DECISION DELEGATED TO HEAD OF PLANNING

Application No:	H22-0931-23	Applicant:	HB Developments Ltd
Proposal:	Details of storage and disposal of refuse and recycling, existing and proposed site levels and proposed floor levels, surface water disposal, foul water disposal, boundary treatments, ecological biodiversity & contamination of land or pollution of controlled waters (Conditions 4, 6, 7, 8, 10, 11 & 12 of H22-0017-23)		
Location:	Plot Between 357 & 363 Broadgate Weston Hills Spalding		
Terminal Date:	15th December 2023

PROPOSED BLOCK PLAN

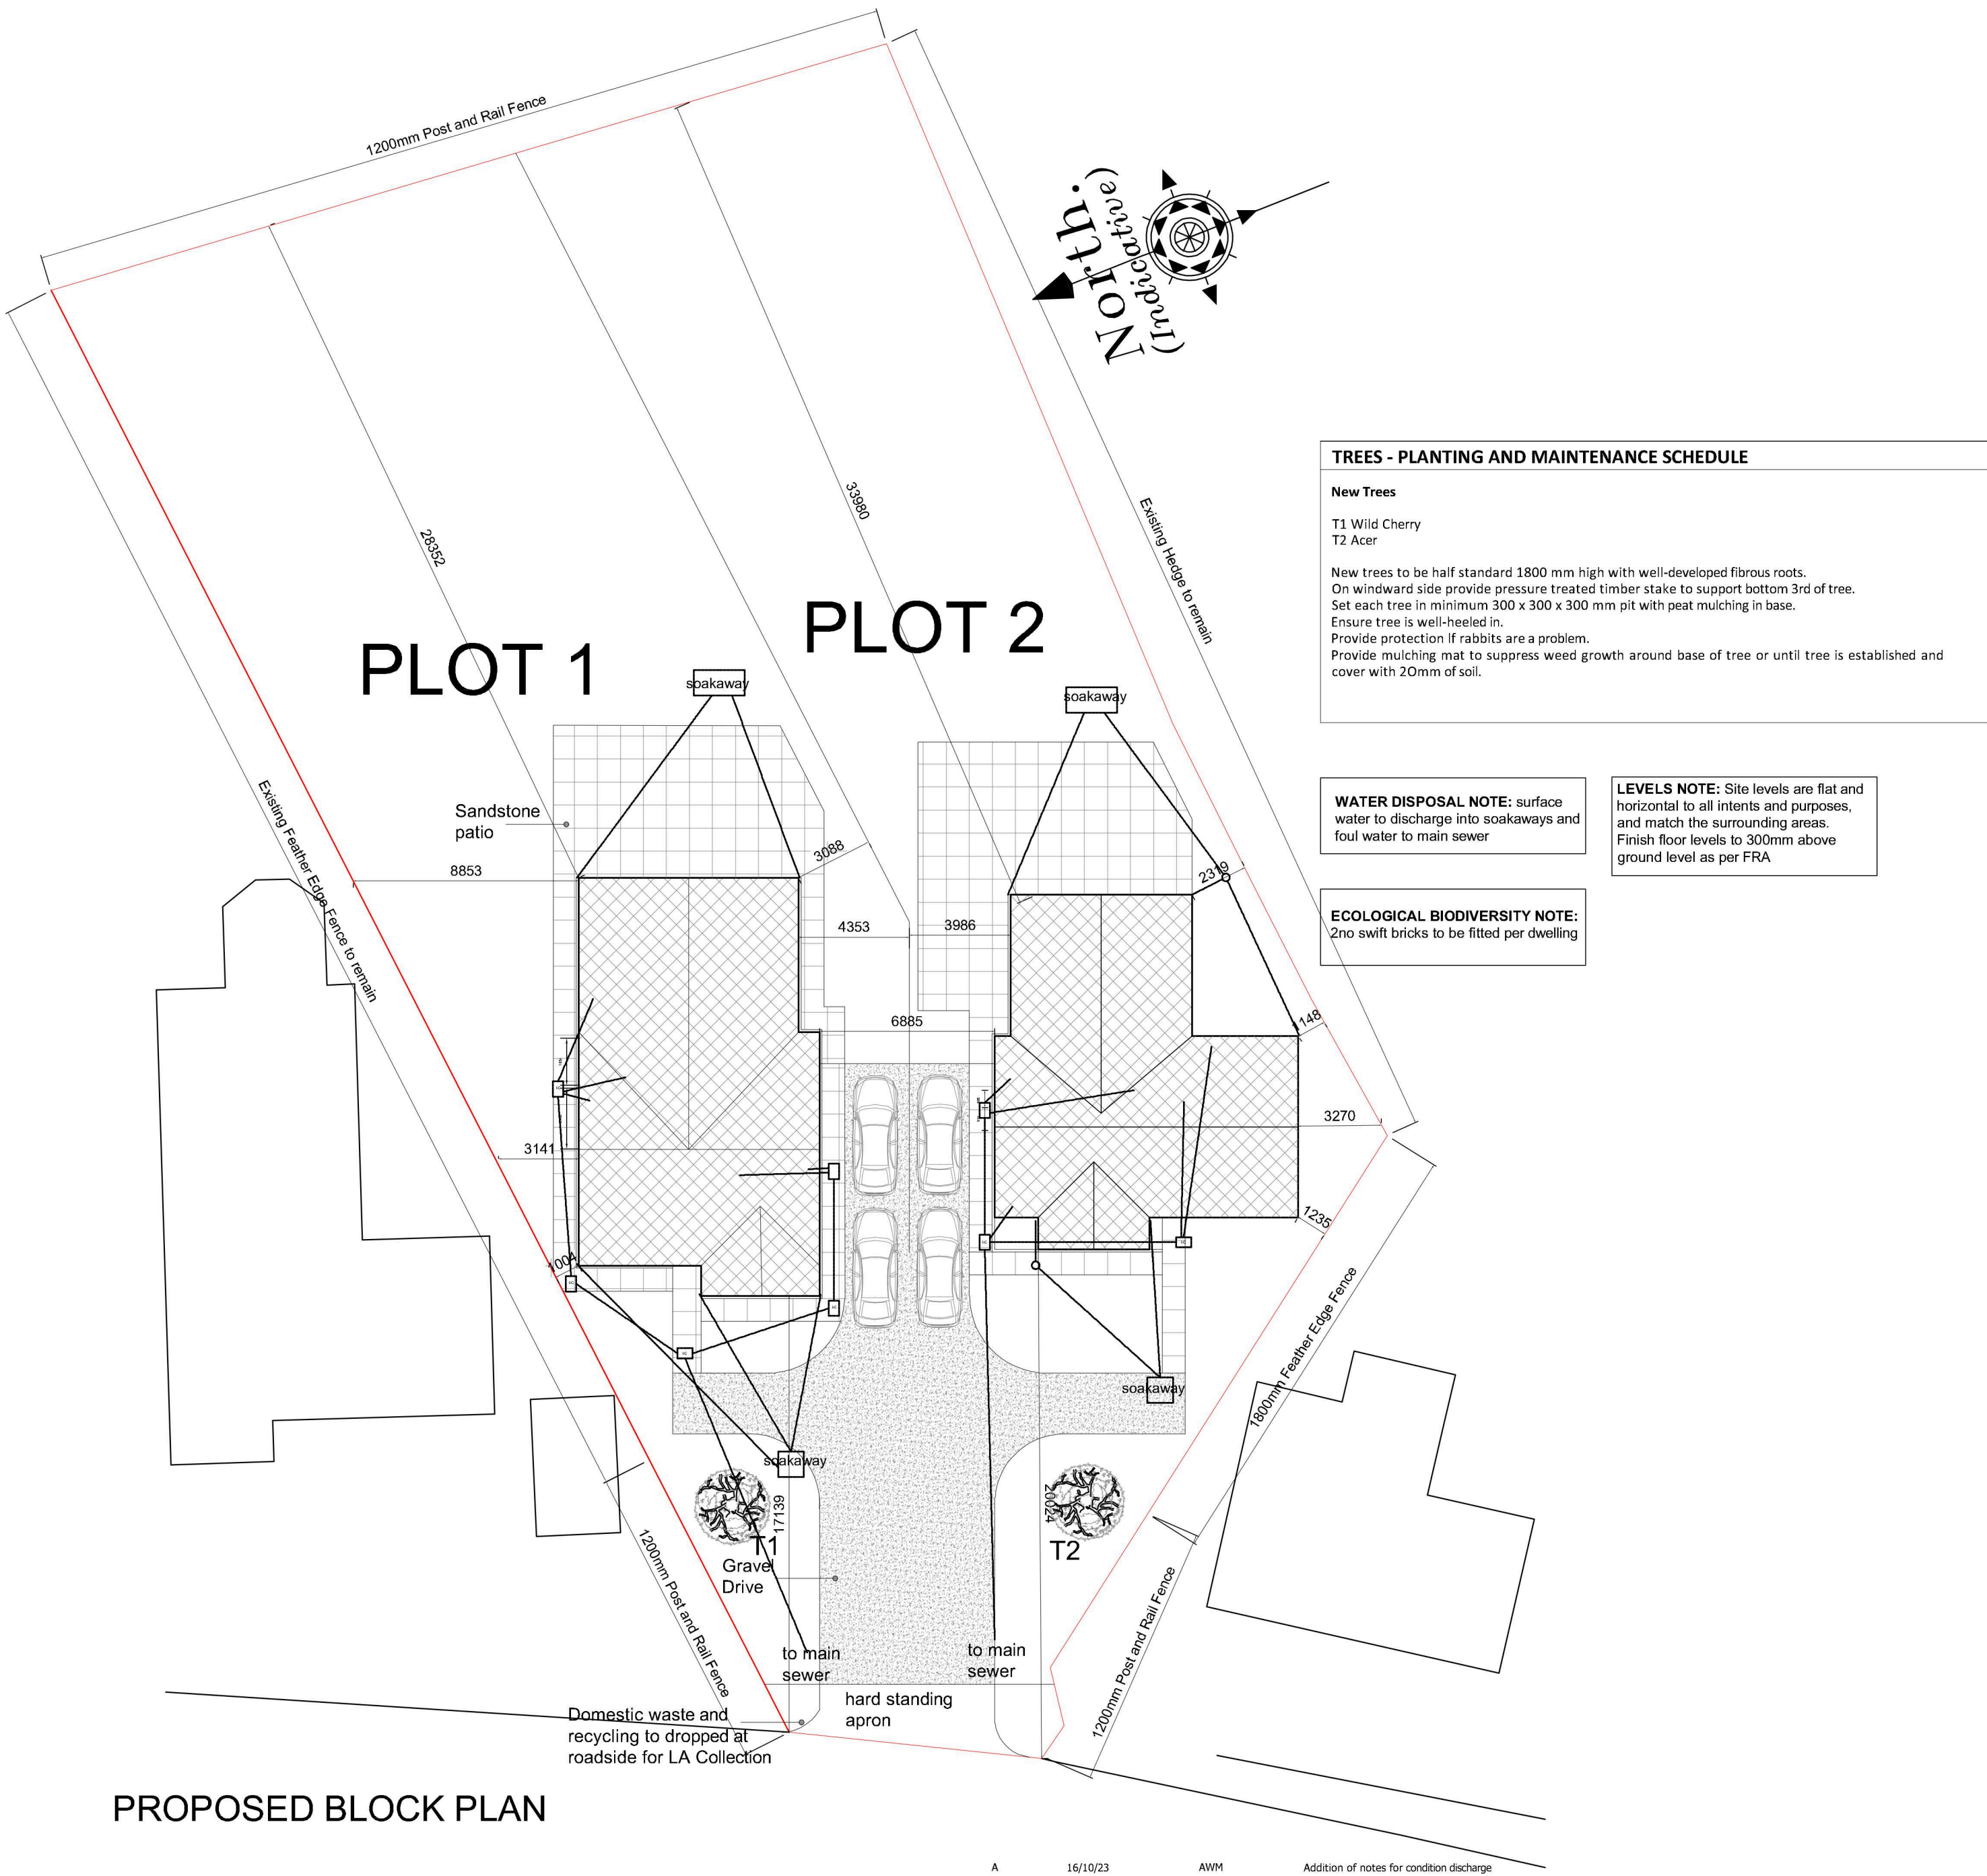
The submitted detail does not provide any reference to existing site levels or proposed site levels, with the exception of a note on the drawing which specifies that the site is 'flat for all intents and purposes'. As detailed within the condition, full details of both existing site levels and proposed site levels, are required. This would include the likes of a topographical survey of the existing levels and a clear demonstration of the proposed site levels for the siting of the dwelling, the amenity/garden areas and any resultant impact in relation to the land nearest to boundary treatments. The detail is significantly lacking for this condition in their current form and is unacceptable. Therefore, this condition should not be discharged.

Whilst details have been provided, in that surface water would be discharged to soakaways, the viability of this proposal has not been evidenced. Consequently, it has not been demonstrated that the proposed surface water drainage strategy is satisfactory. The comments raised by the Internal drainage Board have highlighted these concerns further and as such, it is considered that the detail is not currently in a position to be discharged. Therefore, the condition should not be discharged.

Whilst details have been provided, which include the siting of a 1.2m high fence and the retention of existing fencing and hedging, the detail cannot be assessed appropriately in its current form. This is to a large extent, because the site levels and the resultant impact on Finished Floor Levels have not been provided, which in turn, requires an assessment of the boundary treatment details. Therefore, the proposal currently lacks the required detail for this to be discharged. The submitted details are considered unacceptable and can therefore not be discharged.

The details provided are insufficient to be acceptable to discharge condition 11. The sole ecological 'benefit' illustrated is the inclusion of 'two swift bricks per dwelling'. The provision of two swift bricks is not sufficient to ensure the proposal complies with policy 28 and, it should also be noted that whilst the dwelling is slightly in excess of 5.0metres in height, swift bricks should typically be installed in groups of at least three and above a height of 5.0metres and as such, whilst further provision is required in any event, the proposed swift bricks are also insufficient in their own assessment. These details are therefore unacceptable and can therefore not be discharged.
